**ADC Planning Consultation
Response from the Historic Buildings Adviser**

Application Number	AB/21/15/DOC
Address	12 High Street, Arundel
Description	Application for approval of matters reserved by condition imposed under AB/24/14/L relating to conditions 2, 3, 4 & 5 for a sample panel, Method Statement for repairs, Method Statement for cleaning of timber floors & details of new staircase.
Case Officer	Anita Gardner
Site Visit

Job Title	12 High Street, Arundel		
Client	Jason Fellner		
Drawing Name	Staircase and door opening preliminary details		
Drawing Status	Planning		
Drawn by	AF	Date	1/15
Checked by		Date	
Drawing Scale	1:50 at A3		
Drawing No	Status	Revision	
13509/ 05

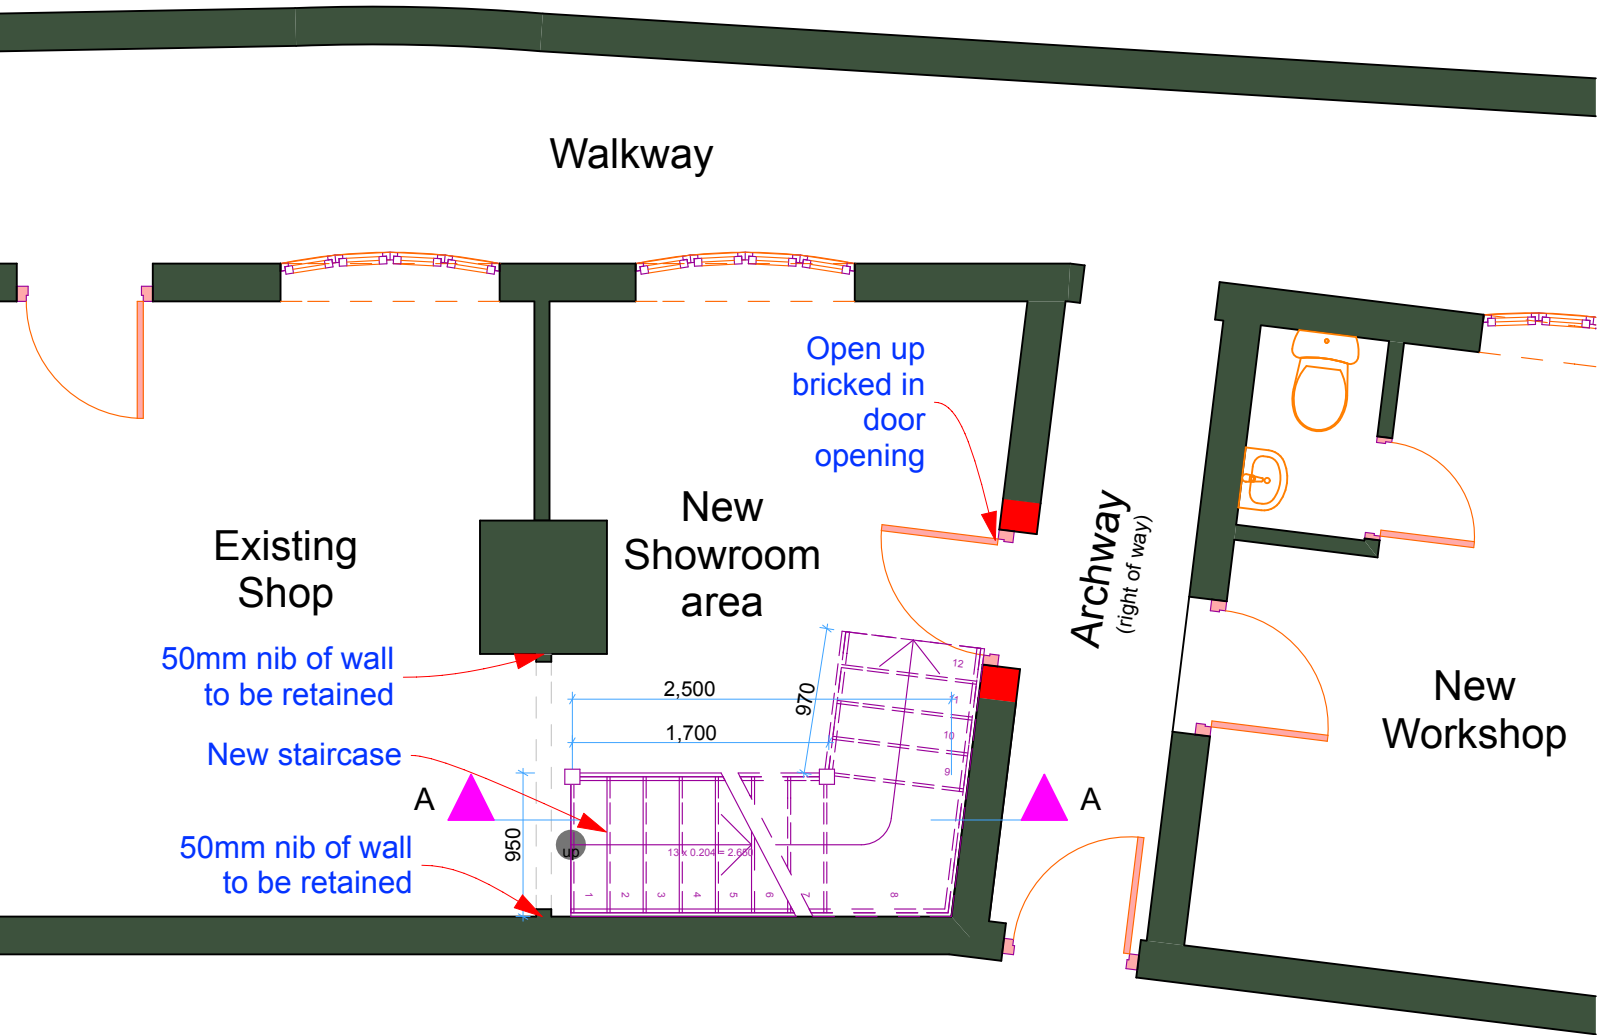
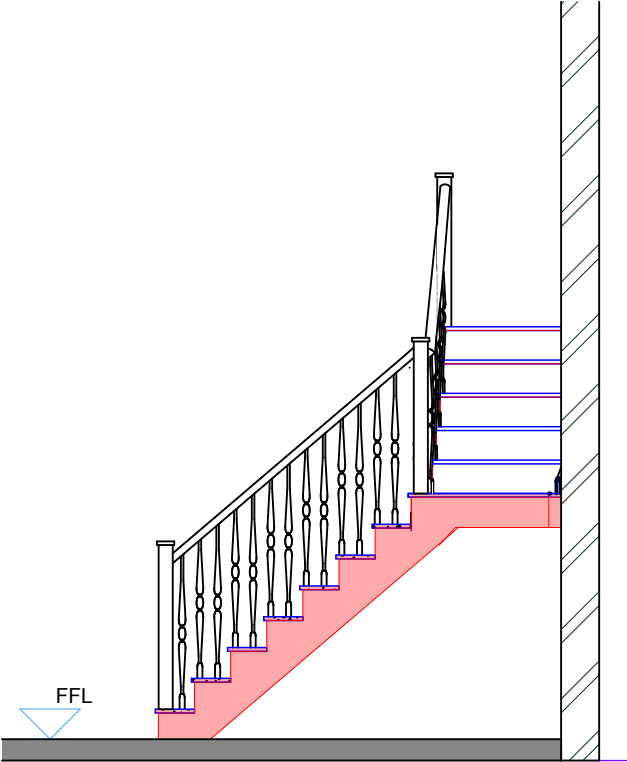
Condition 5: these details are acceptable in this instance, though a larger scale would have been beneficial.
